CITY OF ALBUQUERQUE

March 9, 2012

**Re: Storm Cloud Subdivision, Units 4 & 5
Drainage Report
Engineer's Stamp Date 2/10/2012 (H9/D022)**

**STORM CLOUD UNIT 5
BASIN EXHIBIT**

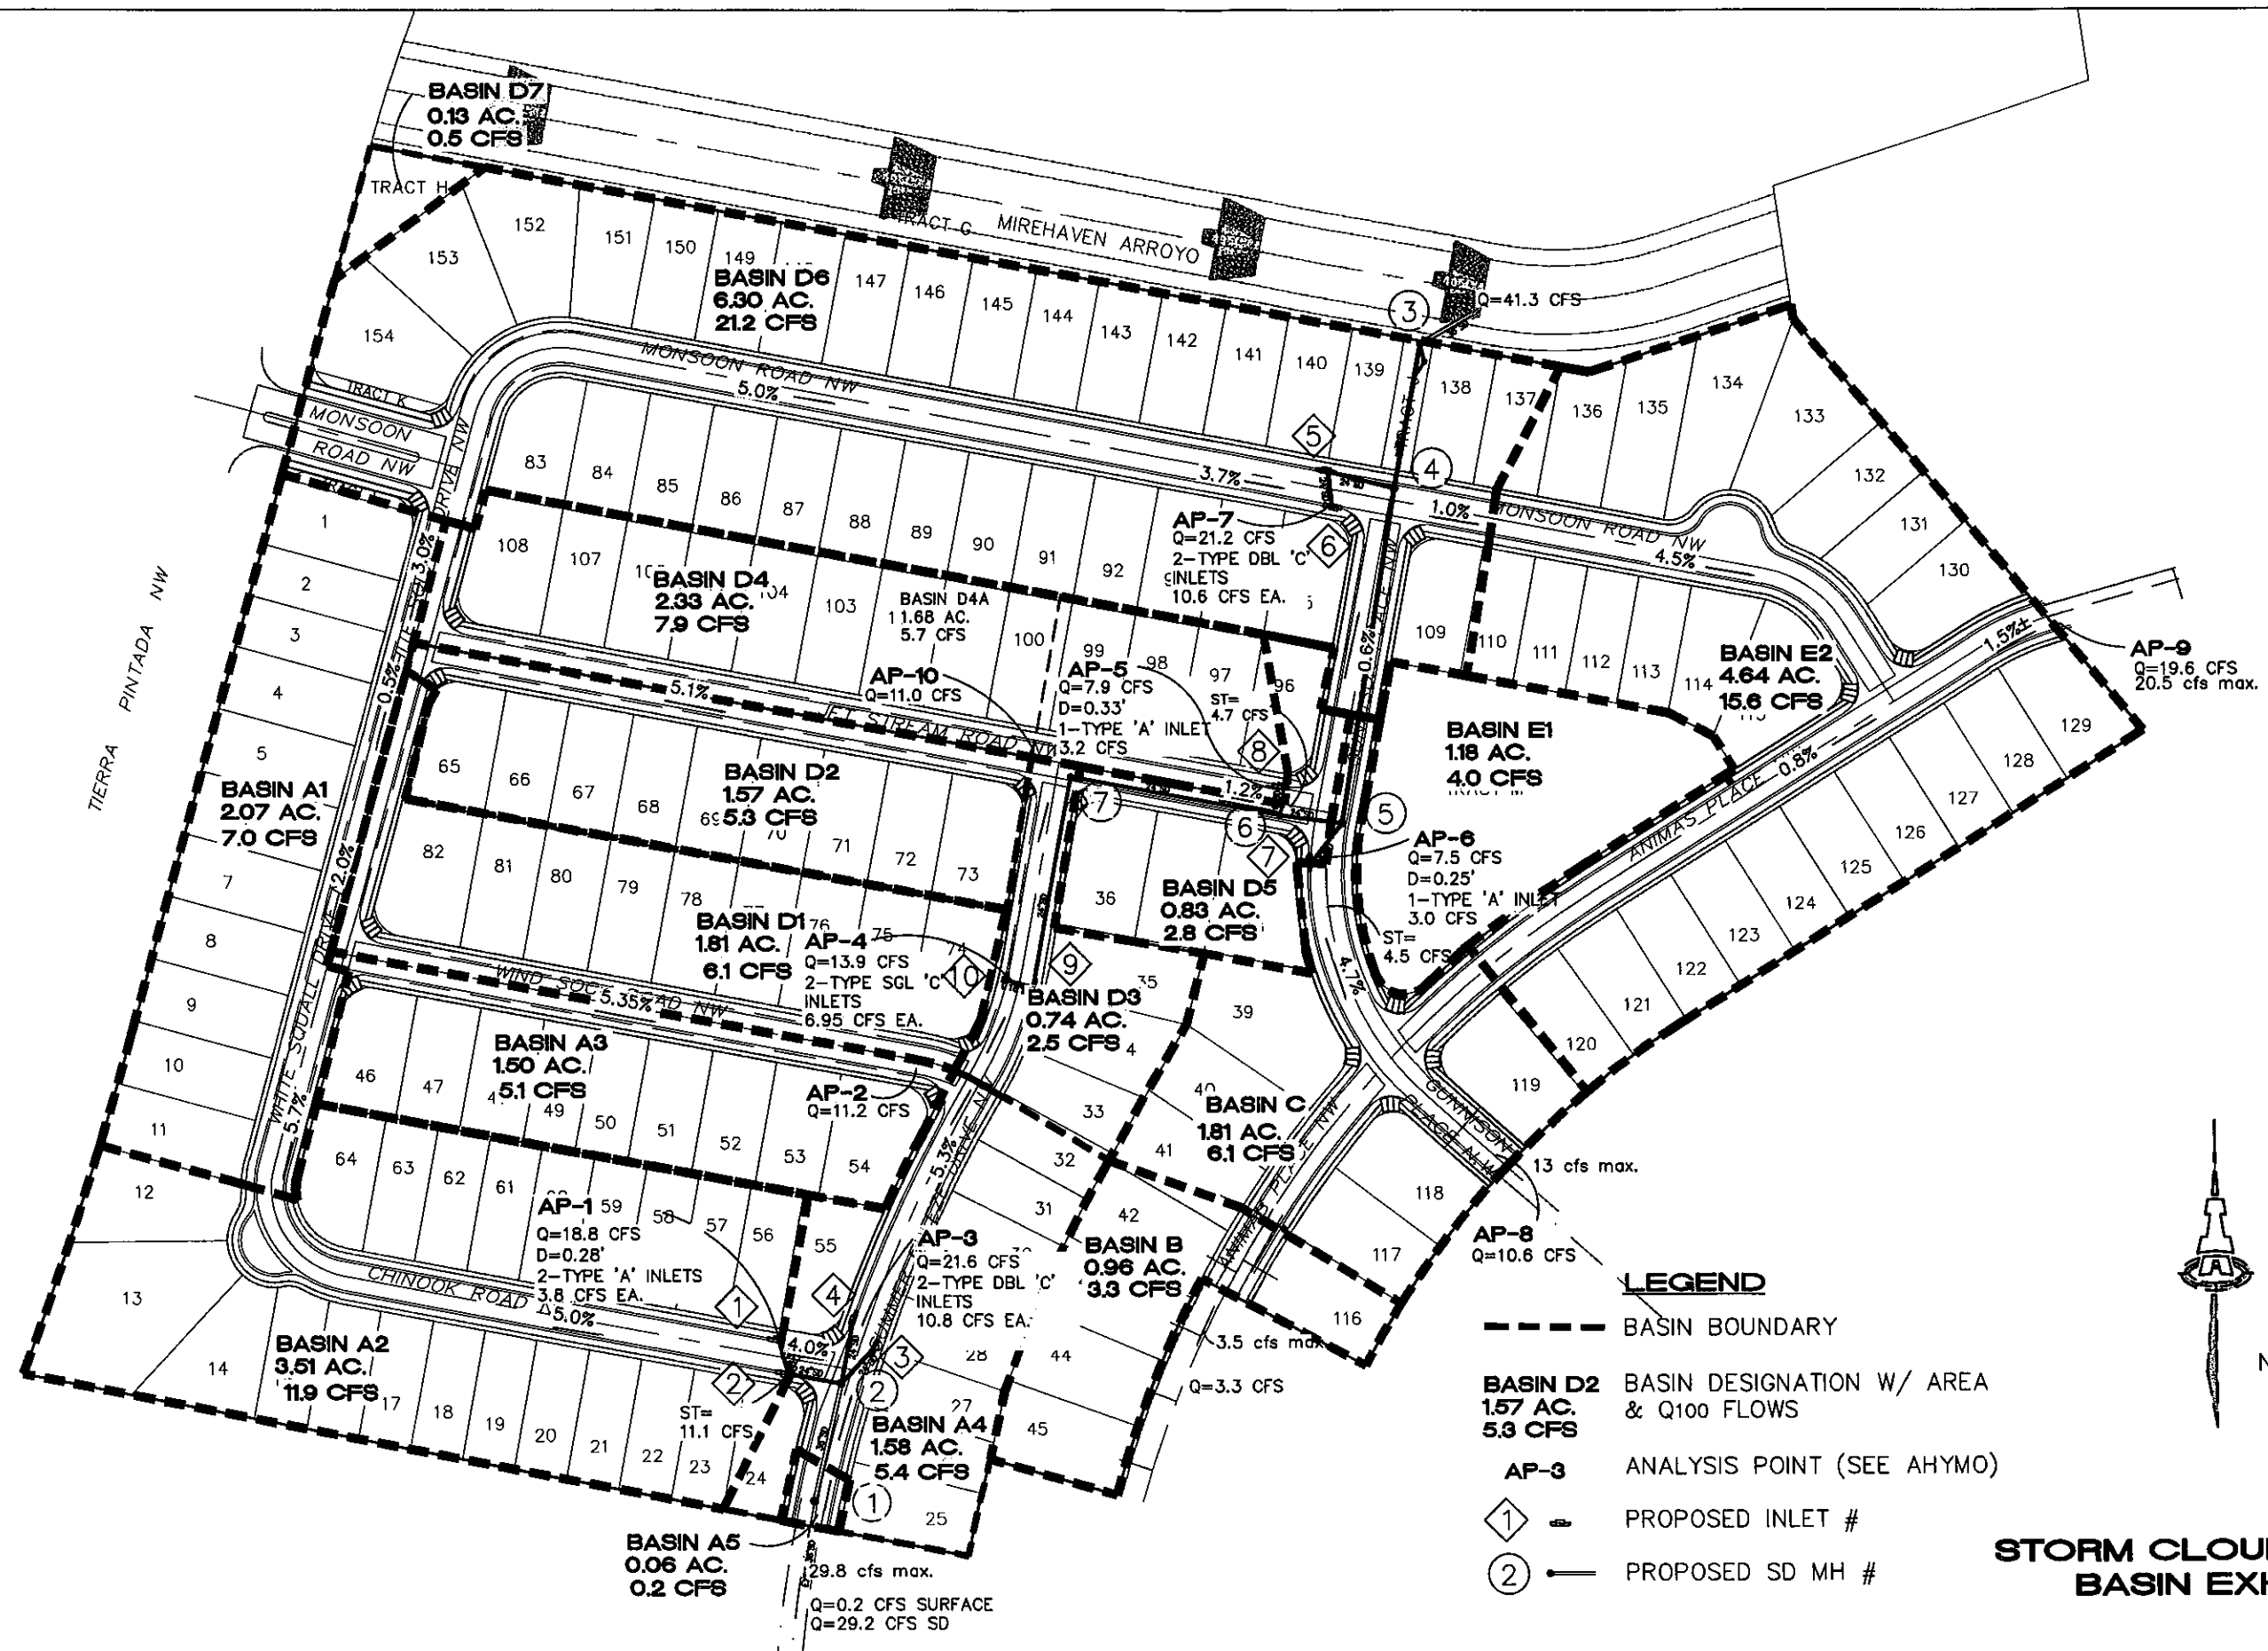
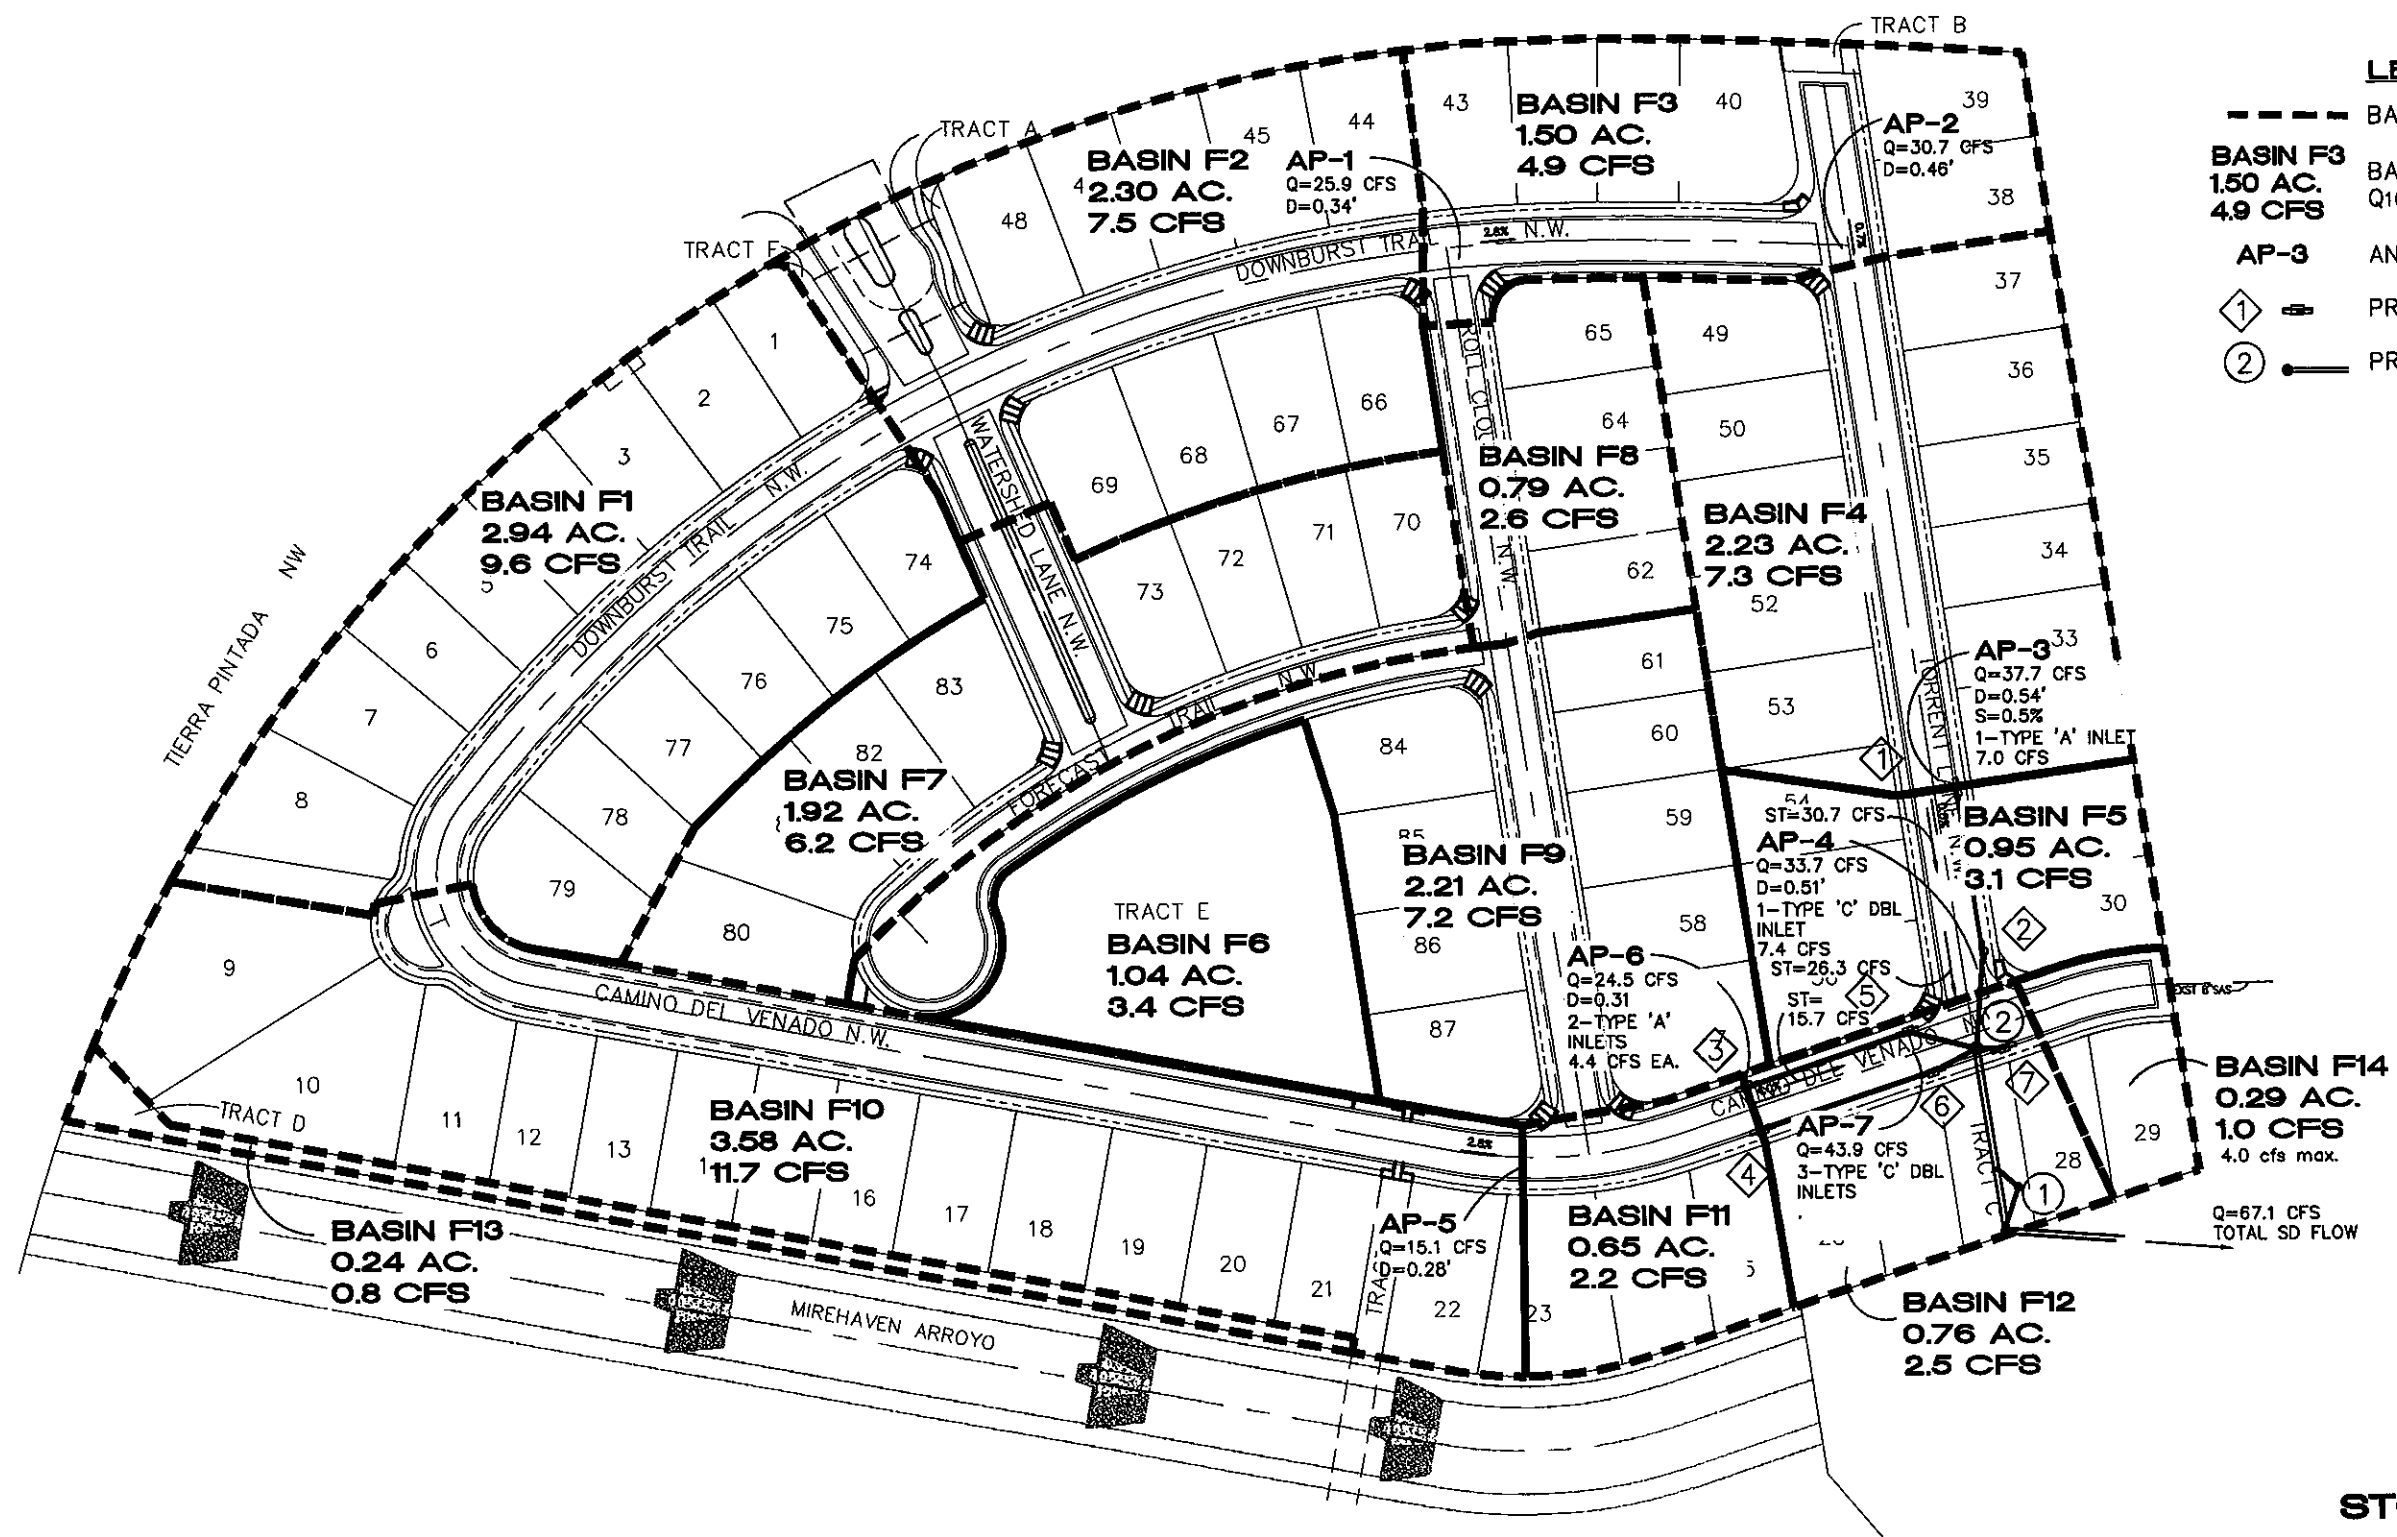
- Appendix E, Unit 4, Inlets 4 and 5 should say 5 & 6 to match the inlet numbers on the Basin Exhibit.
- Inlets 5, 6, & 7 under Unit 5, are designed to be in swamp condition. Please make sure that all three inlets are built with the same top of grate elevation and 0.67' head is provided. The runoff should not overflow to the east. The high point in the street is at 58.67' and grate elevation is at 58.04'.

1823 Mirehaven Arroyo REV Plan: Plan 01 3/19/2012

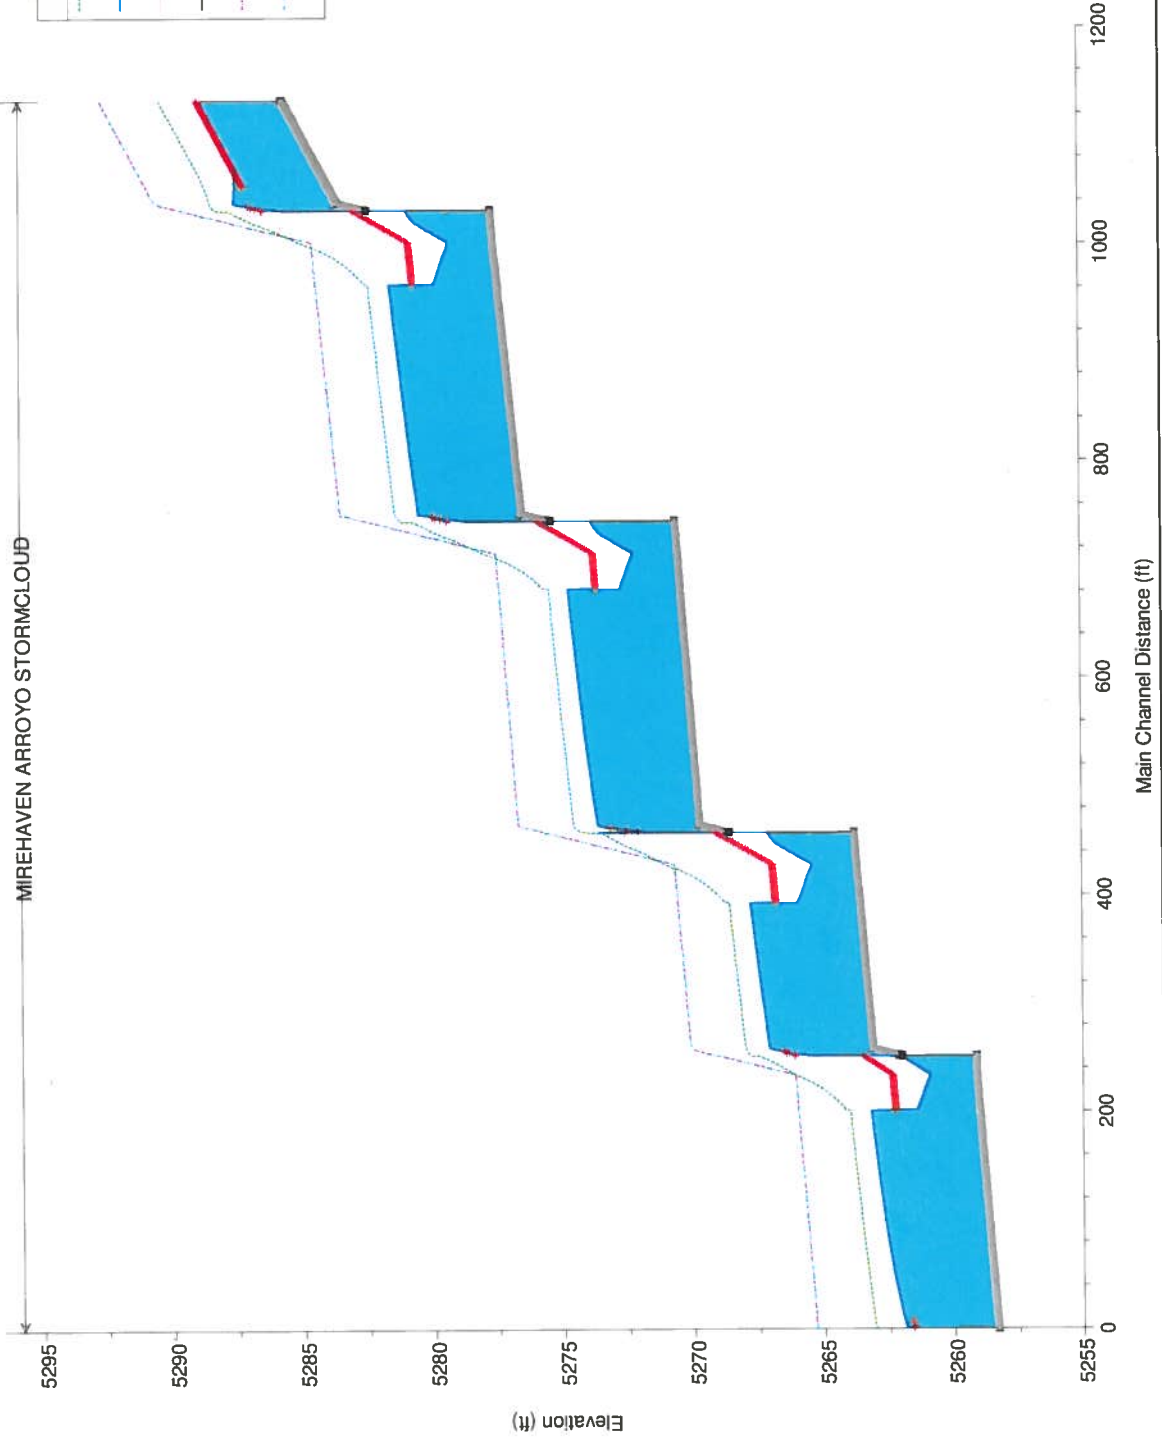
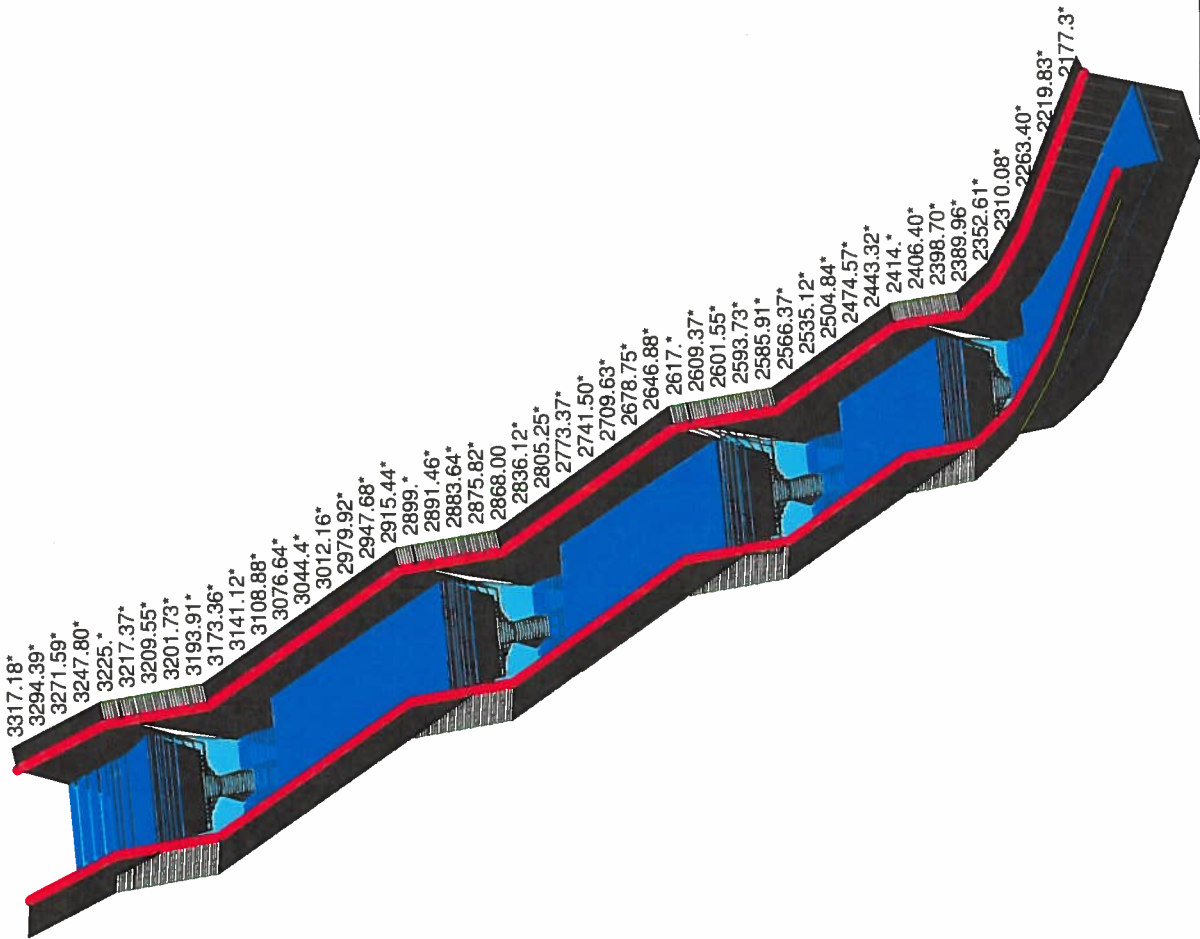
- Show proposed Tierra Pintada Boulevard and grades on the plans.
- Show proposed 3-90" RCPs and grades on the plans.
- Provide updated HEC-RAS analysis for the Mirehaven starting east of the 3-90" RCPs. Include an exhibit showing the proposed floodplain limits east of the culverts and the proposed WSEL/EGL along the Mirehaven Channel.
